# Appeal Decision

**Appeal Ref: APP/T2350/D/24/3346711**

**4 Shaw Terrace, Grindleton, BB7 4RA**

- The appeal is made under section 78 of the Town and Country Planning Act 1990 (as amended) against a refusal to grant planning permission.
  - The appeal is made by Ms D Murray against the decision of Ribble Valley Borough Council.
  - The application Ref is 3/2024/0149.
  - The development proposed is formation of proposed new driveway.
-

Client		
Ms D Murray		
Job Title		
Proposed New Driveway at		
Fern Cottage, 4 Shaw Terrace		
Grindleton		
Drawing Title		
Proposed Site Plan, Section and		
Street Scene		
Scale	Date	Drawn
1:200 @ A3	October 2023	BWT

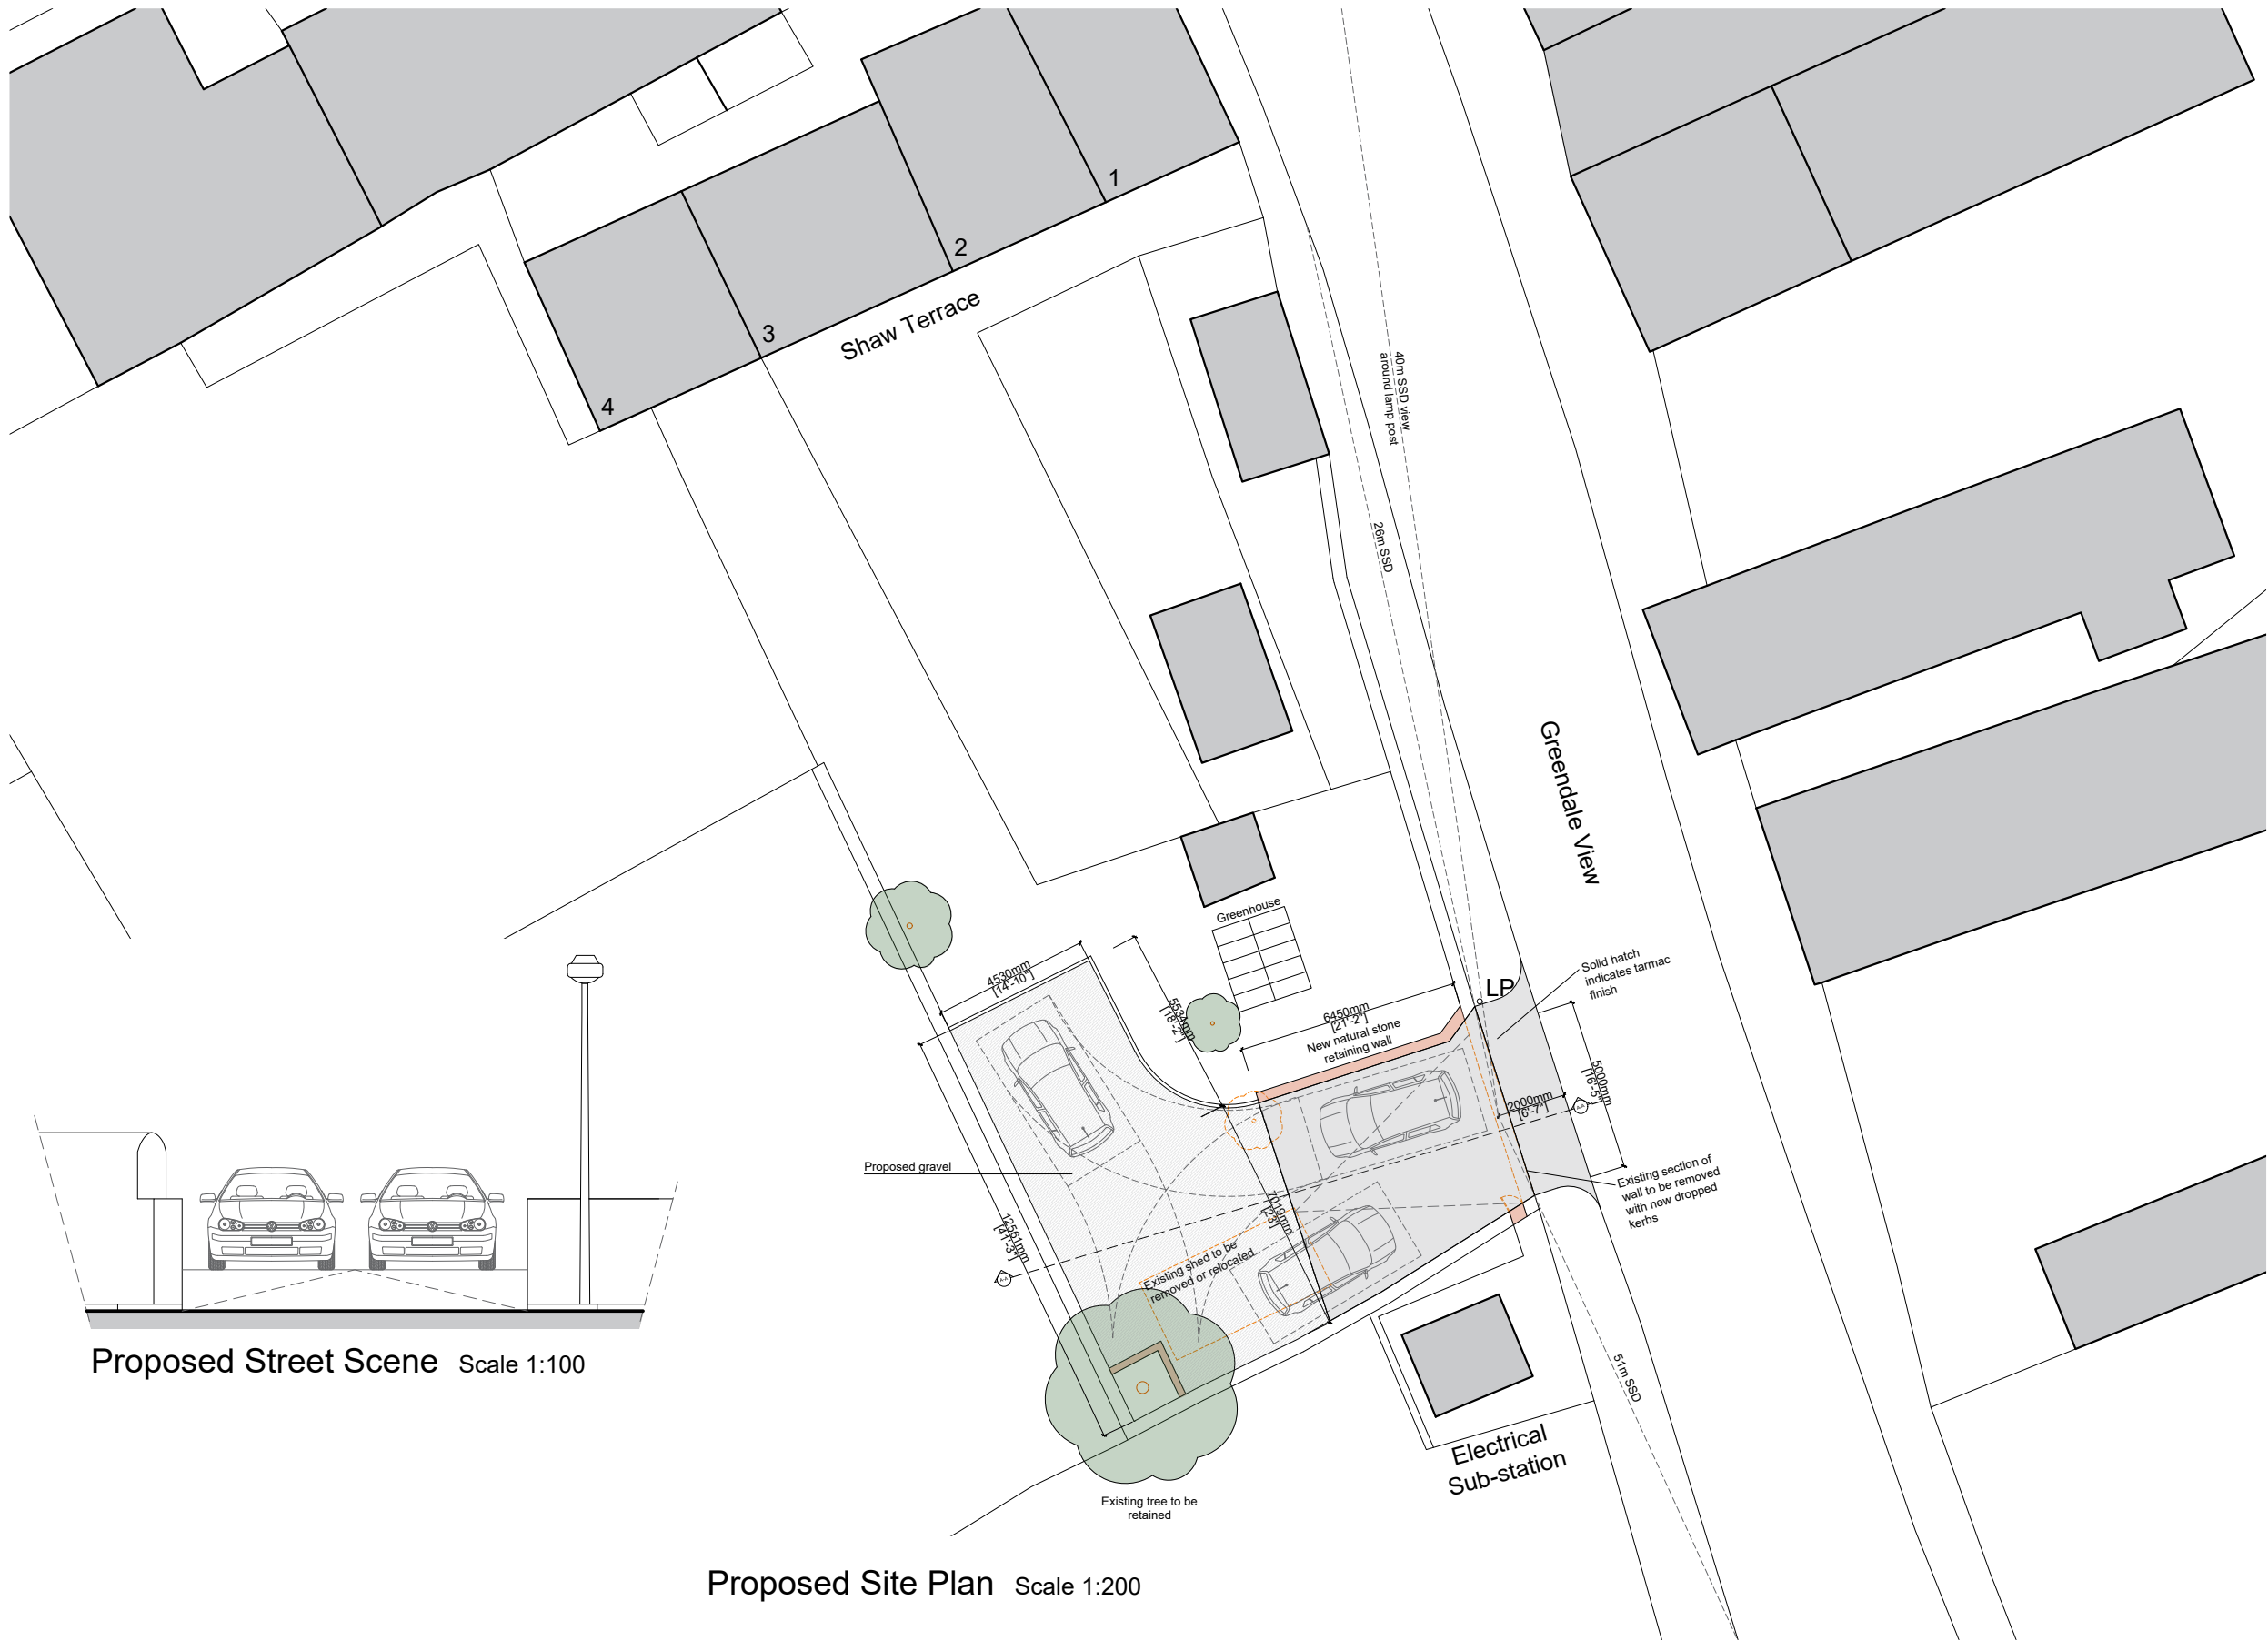
6. The appeal scheme would result in the loss of a section of wall that forms a prominent edge to Main Street. In its entirety, it extends to about 30 metres and approximately 5.5 metres would be removed to facilitate the driveway. Whilst the appeal site is not identified as a significant open space, nor within a key view within the GCAAA, it is the unbroken consistency of this wall, combined with its prominent position along a key route through the village, that significantly contributes to the quality of the area. Although stone boundaries elsewhere along Main Street are occasionally interrupted by pedestrian or vehicular entrances, or access to land to the rear of the main road, the loss of this significant section of walling would be sufficiently noticeable at street level to result in harm to the character and appearance of the street and, therefore, to the GCA.

7. Furthermore, the car parking and turning area would be at a slightly elevated level to the pavement. Consequently, the opening would provide a direct view into this raised driveway. Whilst the boundary wall to either side of it would partly screen any parked vehicles, it would not be so high as to conceal them completely. The parking area would also be sited some distance from the appeal property towards the bottom of the garden. From the site, I observed no other driveways that were similarly located, with other parking areas being typically within the front garden or adjacent to the dwelling. Even if any parked cars would be seen within the context of the existing garden outbuildings, the driveway would nonetheless be visually prominent within the street scene. It would therefore be harmful to the character and appearance of the area and fail to make a positive contribution to the GCA.
